# **Gatwick Northern Runway TR020005**

## **PRINCIPAL AREAS OF DISAGREEMENT SUMMARY STATEMENT – DEADLINE 9 UPDATE**

August 2024

**GATWICK NORTHERN RUNWAY PROJECT – PRINCIPAL AREAS OF DISAGREEMENT SUMMARY STATEMENT – DEADLINE 9 UPDATE**

Project Code-Location-Discipline-Volume-Type-Unique Number
41700- XX -B- LLO- GA - 200177 P01

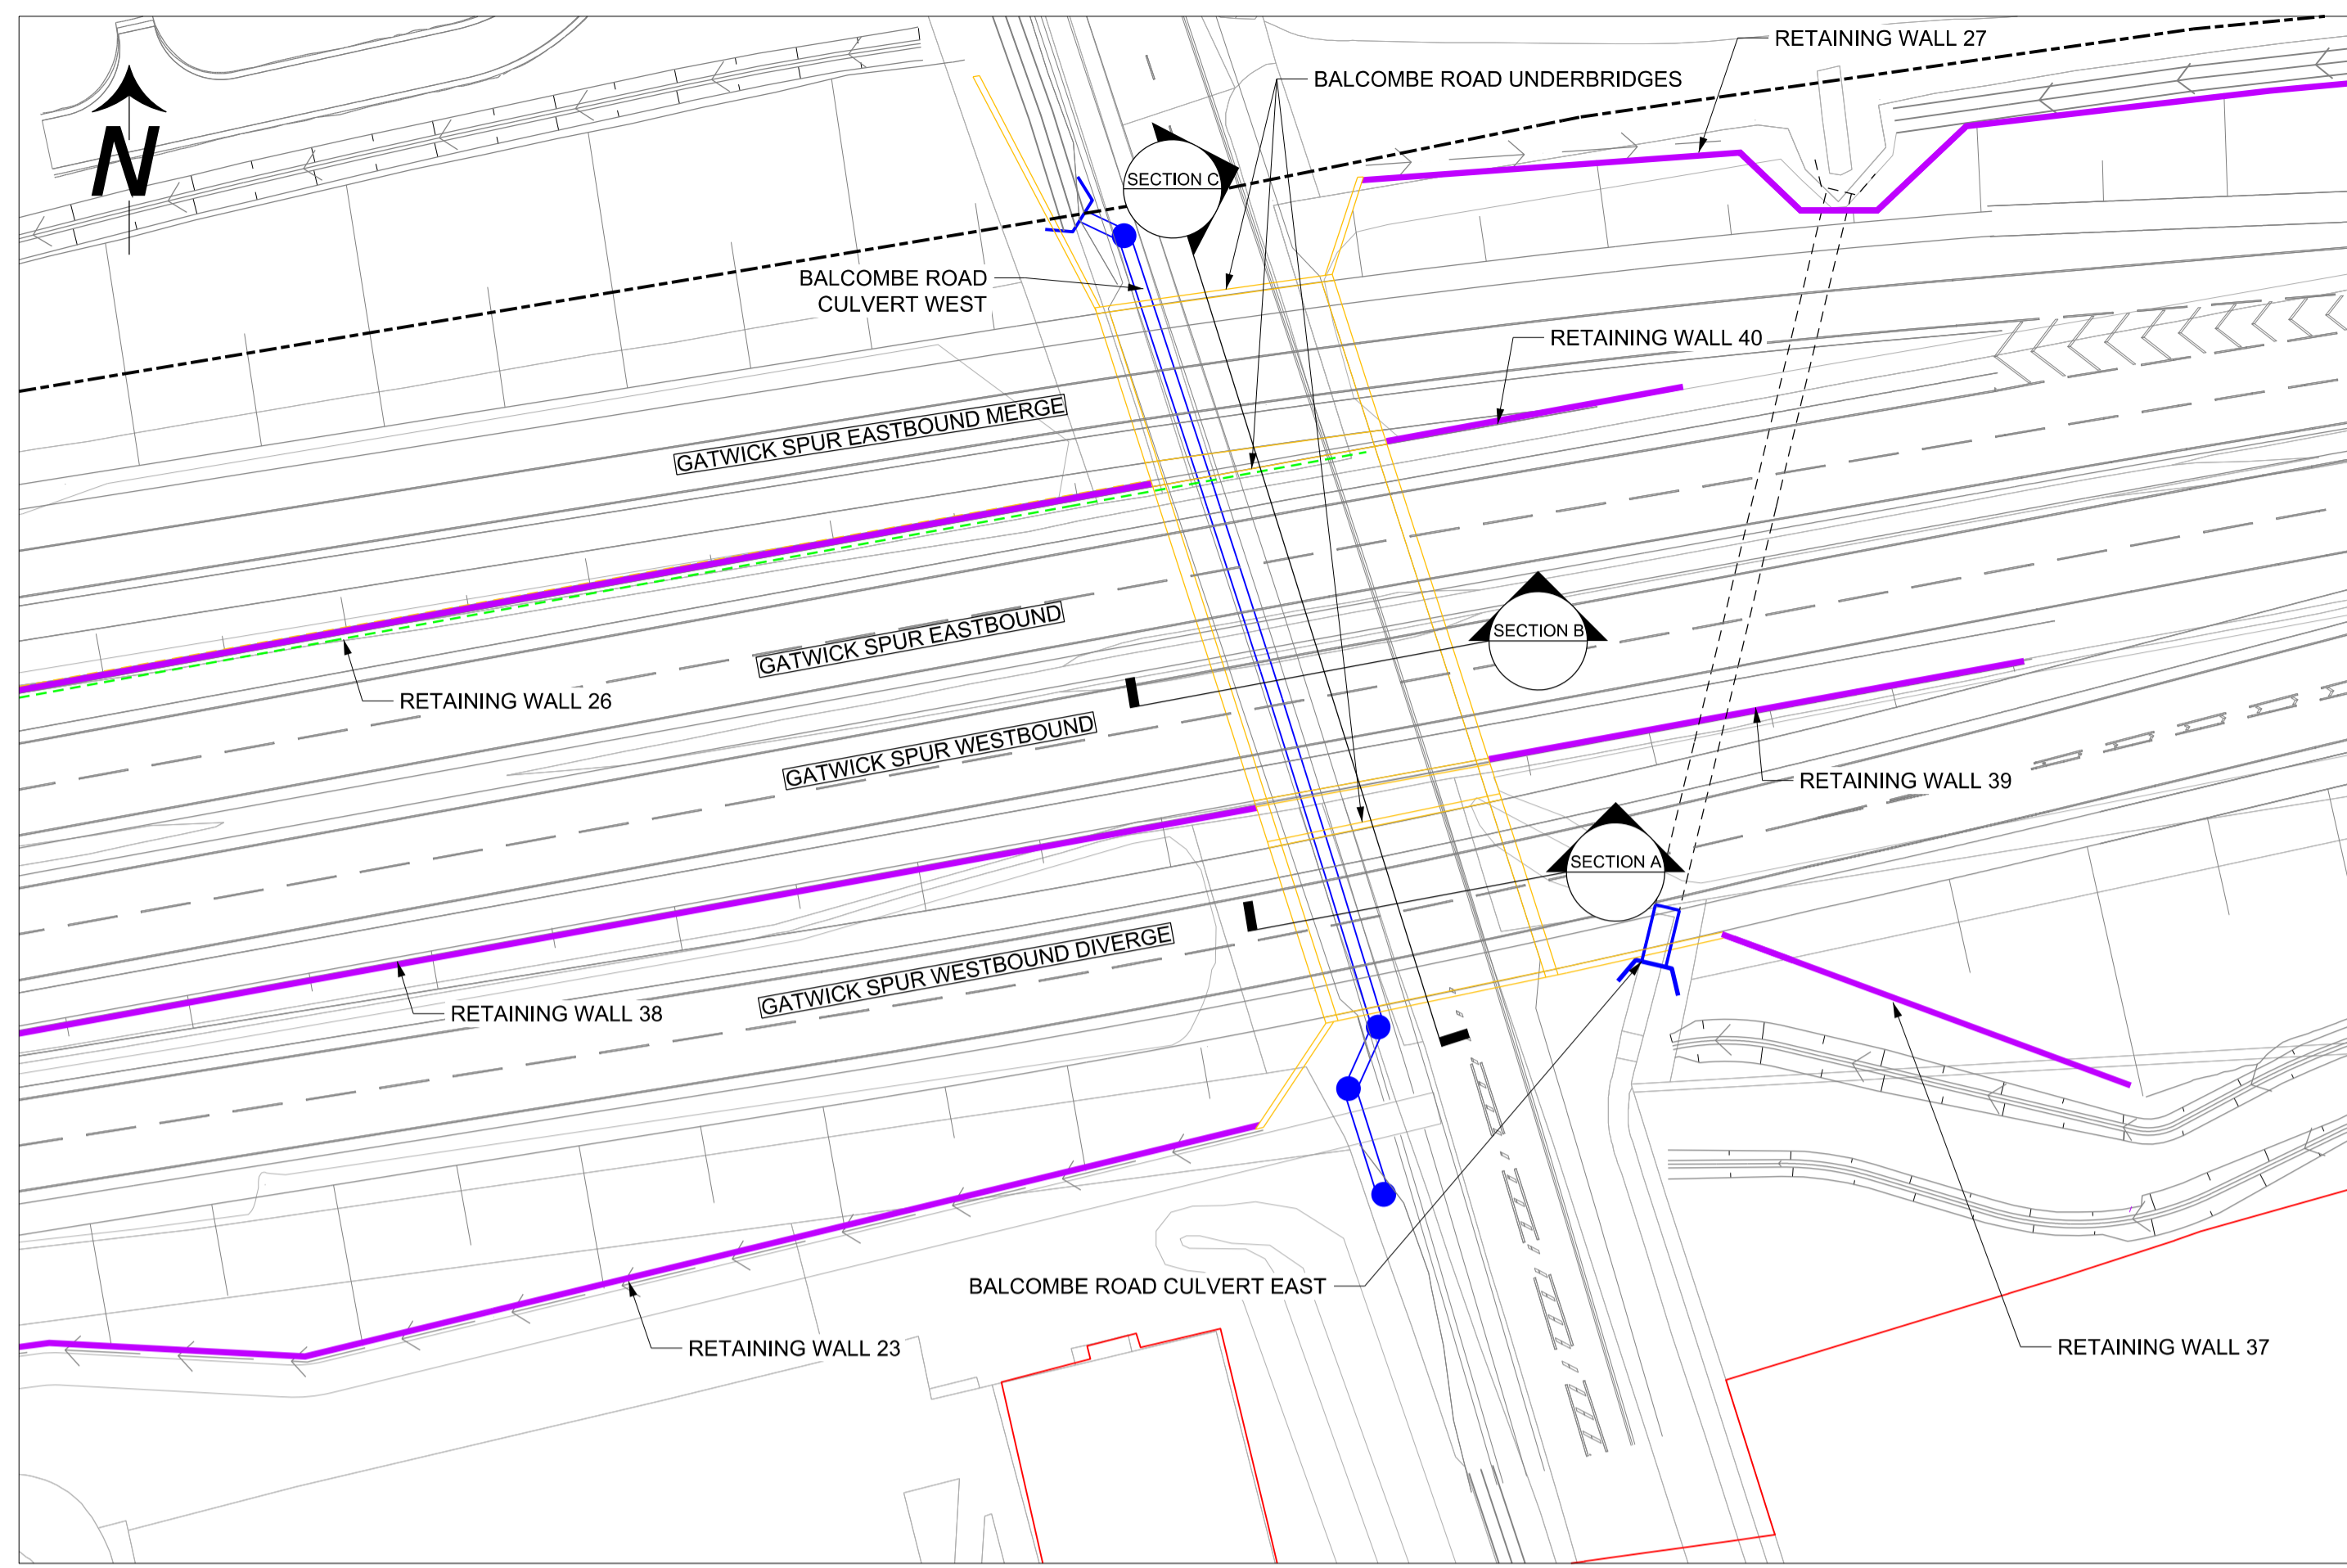
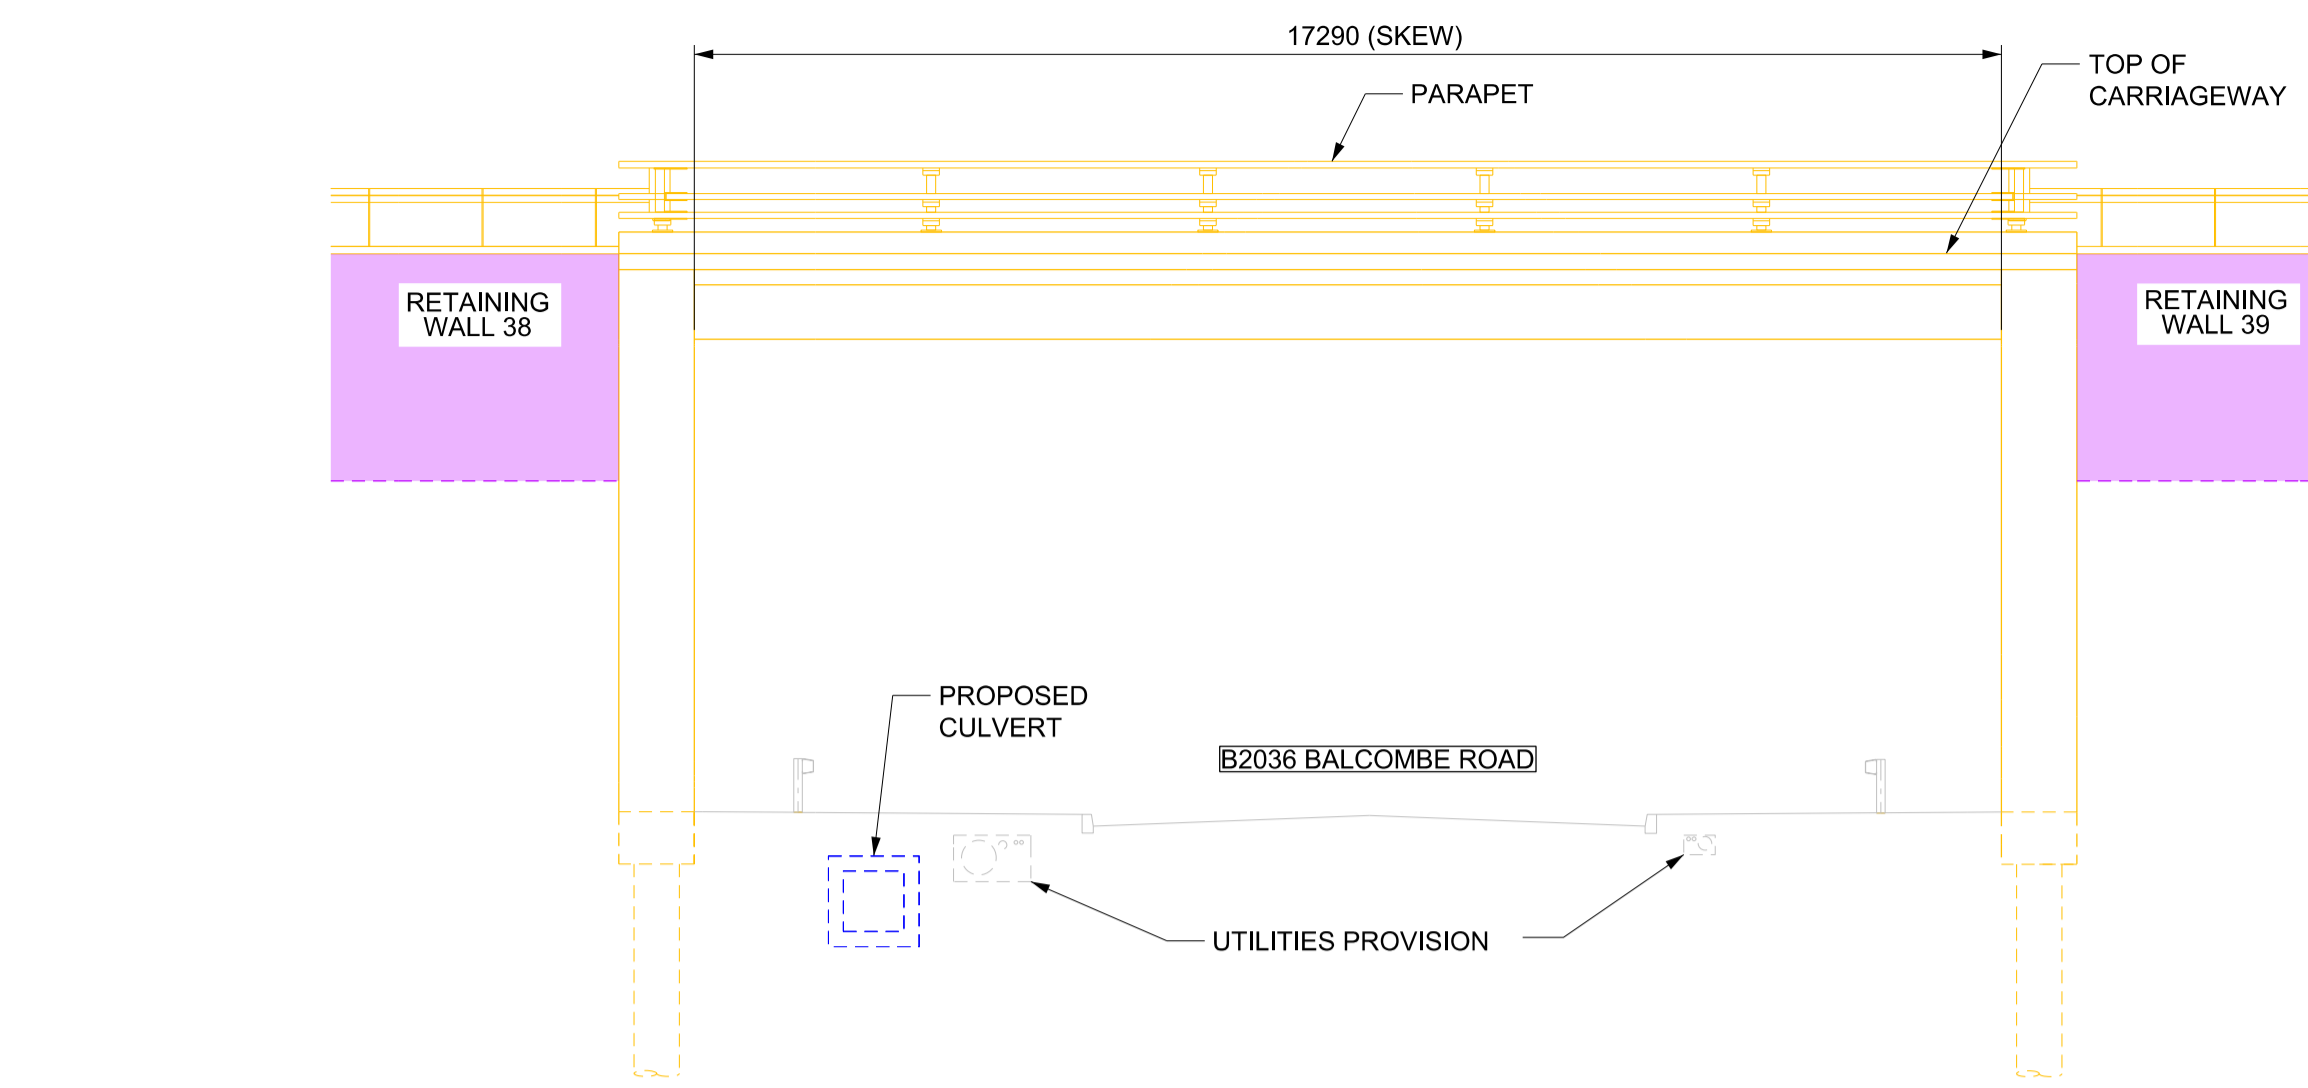
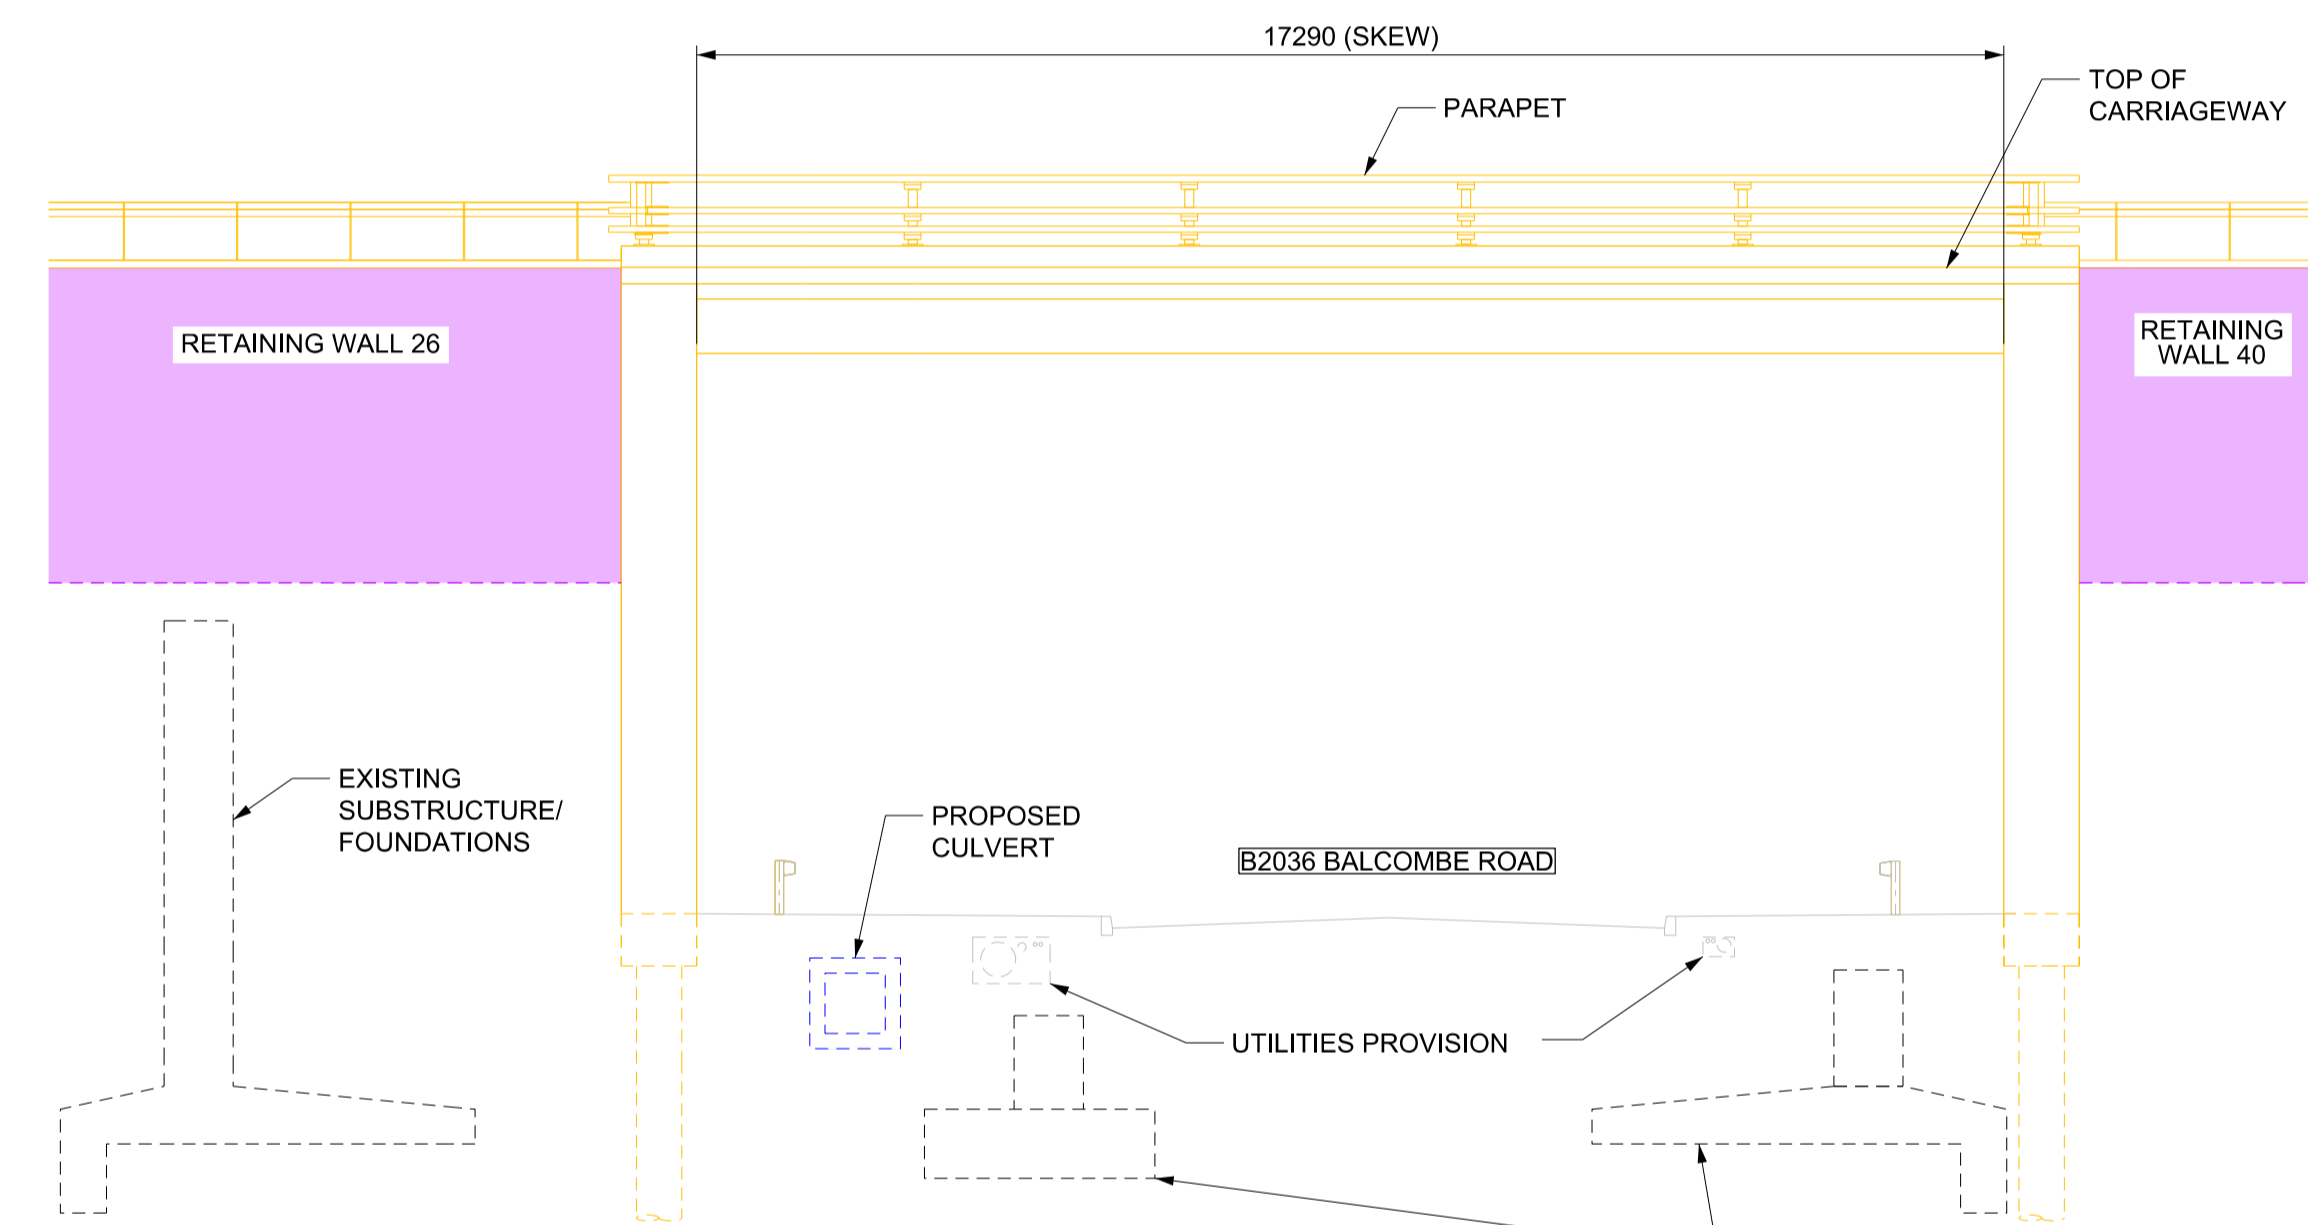
36 2.20.5.6	Structure Section Drawings (TR020005/APP/022)  Drawing 41700-XX-B-LLO-GA-200178	This drawing provides a section through the Balcombe Road Underbridge. For the Gatwick Spur Eastbound carriageway Section C - C, this section denotes the presence of the noise barrier but does not indicate there being any structural parapet or edge restraint system on the parapet edge beam.	The Applicant is to confirm whether there is edge restraint being provided on this area and, if required, ensure that this drawing is updated.  <b>Updated position (Deadline 2):</b> National Highways has reviewed the proposals by the Applicant and recommends the Applicant considers the following two options:  If maintenance activities require operatives to access to the rear of the noise barrier, a pedestrian parapet system is to be installed on the structure to act as an edge restraint to minimise the risk of falling.  If there are no maintenance activities required to the rear of the noise barrier, the noise barrier is to be repositioned on the structure to sit on the plinth, thereby restricting any unauthorised access to the structure. If this solution is considered by the Applicant, the relocation of the noise barrier may need to be considered as part of any acoustic assessments.  <b>Updated position (Deadline 5):</b> National Highways notes the Applicant's response and requests that the Applicant provides details of any revision to the structure for comment in line with the strategy that National Highways articulated in its updated PADSS under item number 36 submitted at Deadline 2 [REP2-053].  <b>Updated position (Deadline 9):</b> <a href="#">National Highways can confirm that the Framework Agreement signed between both parties affords National Highways the necessary level of protection to ensure that this matter can be agreed for the purposes of the Development Consent Order Examination.</a>	<b>High</b>	<b>Yes</b>  <b>Matter concluded at Deadline 9</b>
